30 January 2026

Thunderbolt Wind Farm Modification 1 (MOD1) (SSD 10807896) - Muswellbrook Shire Council (Staff) comments on the Modification Report

Figure 1: Haulage route

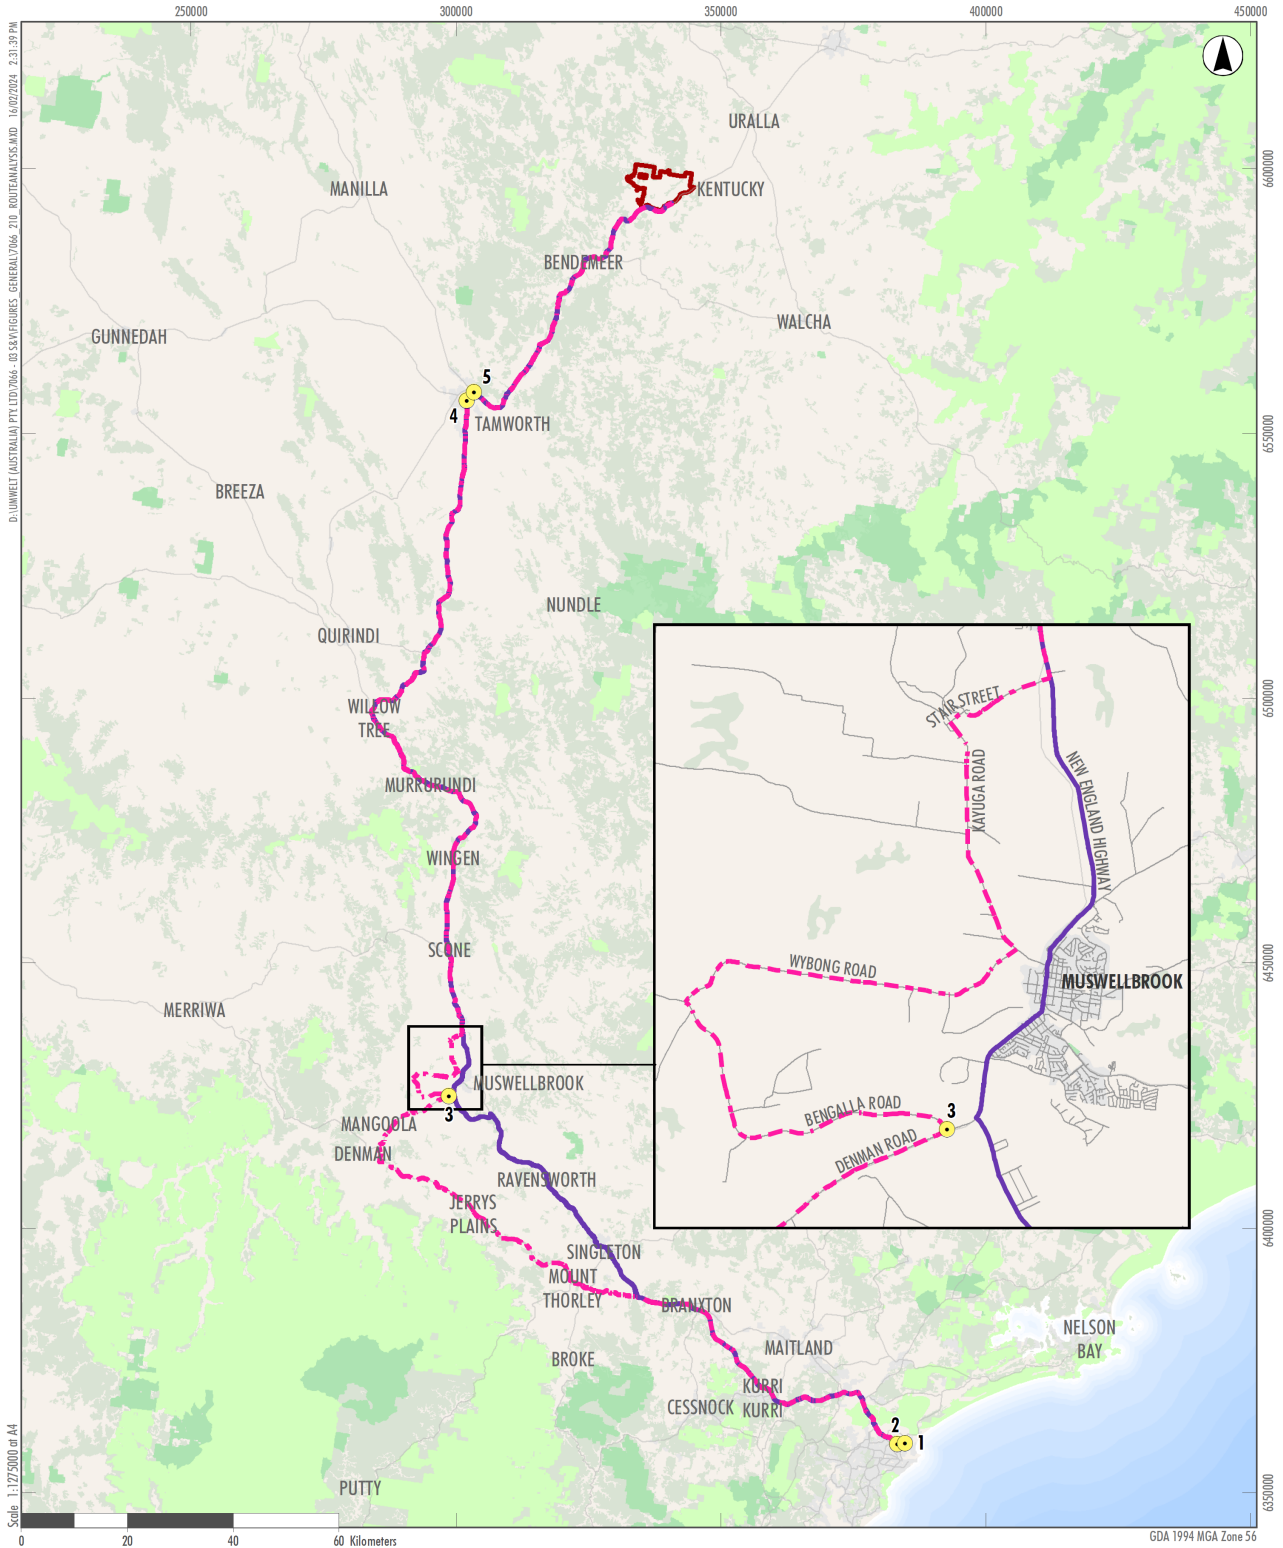
1. Council's current position on the movement of Over Size Over Mass vehicles to access another shire is outlined below:

In addition to this, the structural integrity of the bridge structures in Bell Street and Bengalla Link Road are an ongoing concern to Council and we may, at any time, need to impose weight limits on these bridge structures if they deteriorate rapidly or are damaged. This would impact many other road users within and external to the Shire.

There is also an issue with many projects having approvals with no conditions of consent that require them to make payments to Muswellbrook Shire Council under a Contributions Plan. For all these reasons Council is unlikely to support Option 1b (Wybong Road east,

Kayuga Road, Stair Street) if not classified as a State Road or unless the State Government agrees to charge the various proponents a road use fee to cover maintenance and deterioration of the road assets.

Therefore, Council's current position is an objection to the OSOM movements proposed by the Thunderbolt Wind Farm.

3. In March 2025, Transport for NSW undertook an inspection and structural assessment of Keys Bridge over the Hunter River on Bengalla Link Road. The inspection 'revealed significant structural concerns' with the bridge.

Staff will raise this matter with EnergyCo and continue to liaise with Transport for NSW; however, in its current condition, Keys Bridge is considered unsuitable for ongoing OSOM movements associated with the New England REZ.
